AN BORD PLEANÁLA	
13:00	(21)
28 SEP 2022	
LTR DATED _____	FROM _____
LDG- _____	Submission to Oral Hearing
ABP- _____	An Bord Pleanála

NA04.310286

XC212 (Ballycoskery Level Crossing)

# PLAN 4A (ii) XC212 - BALLYCOSKERY

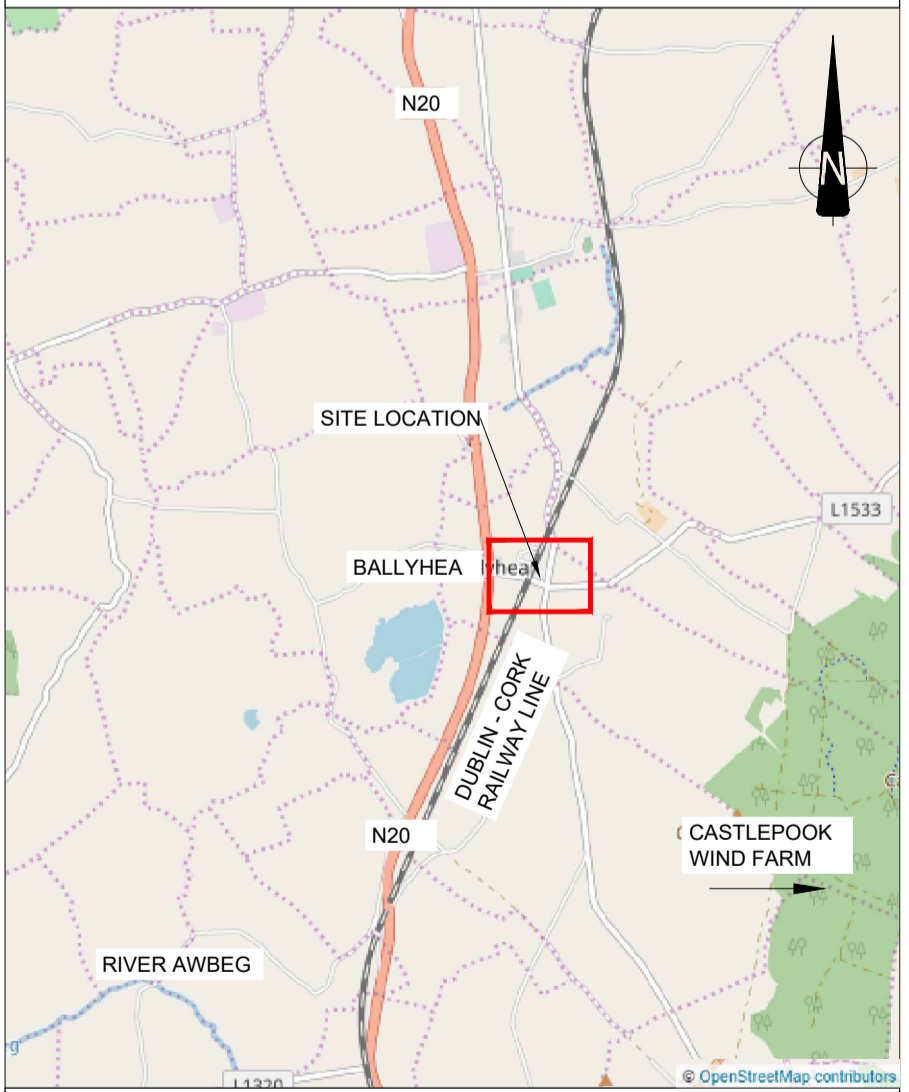
It is very clear that the cost of the project at XC212 is the overarching factor and no real consideration is been given to the people or the environment. Beechwood drive is a quiet residential area in the heart of Ballyhea and the Proposed Over-Bridge would have a negative impact on the residents in this area.

It would also have a negative impact on the value of the property in this area. The proposed routes for the M20 are also adjacent to this area and will only compound the issue.

Figure 4-9 XC212 Alternative options

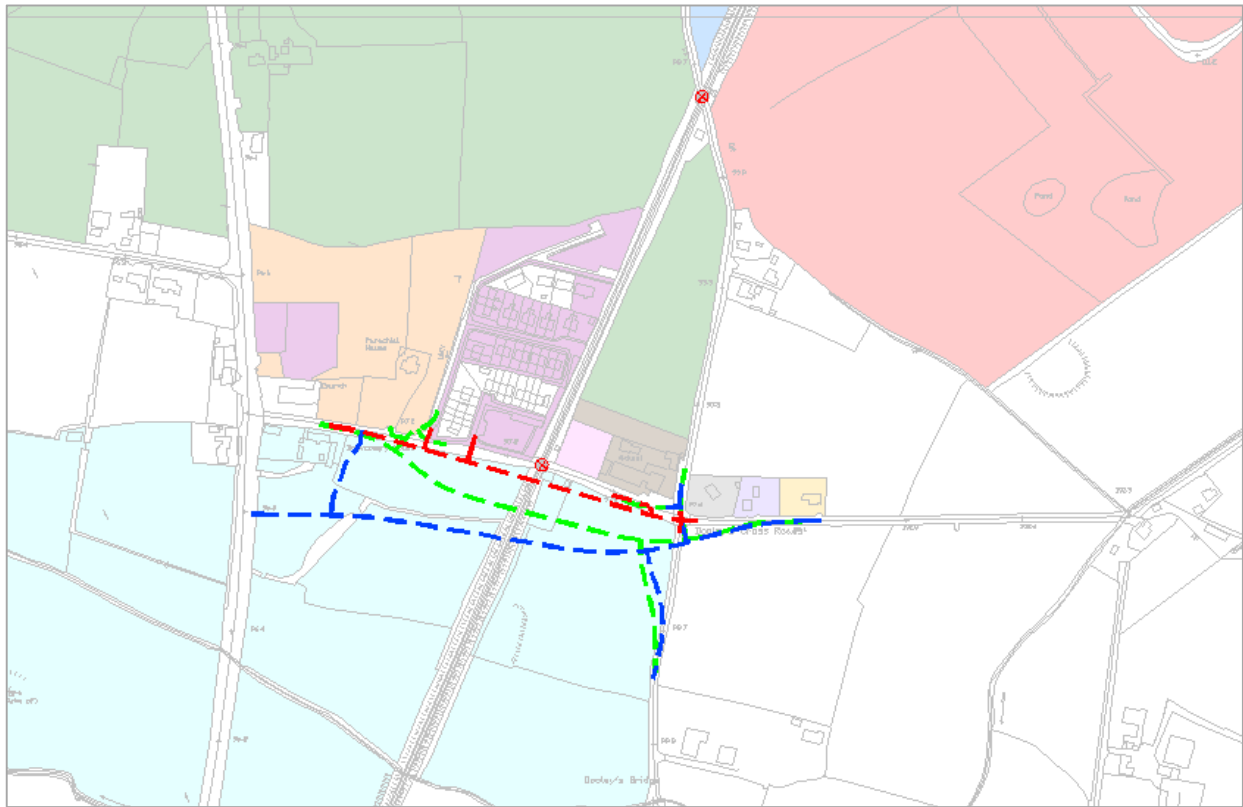
A decision was made to favour the "Green" route as outlined in the Preliminary design report.

In the route selection it states that this is the Less preferred option for Noise compared to the other options. Nowhere in the report does it quantify the levels of noise pollution that can be expected were this Over-Bridge to be completed.

We, the residents, have tried to engage with Irish Rail since 2011 and proposed an alternative route "Blue Route" which would be accepted by the residents which we feel was never taken seriously.
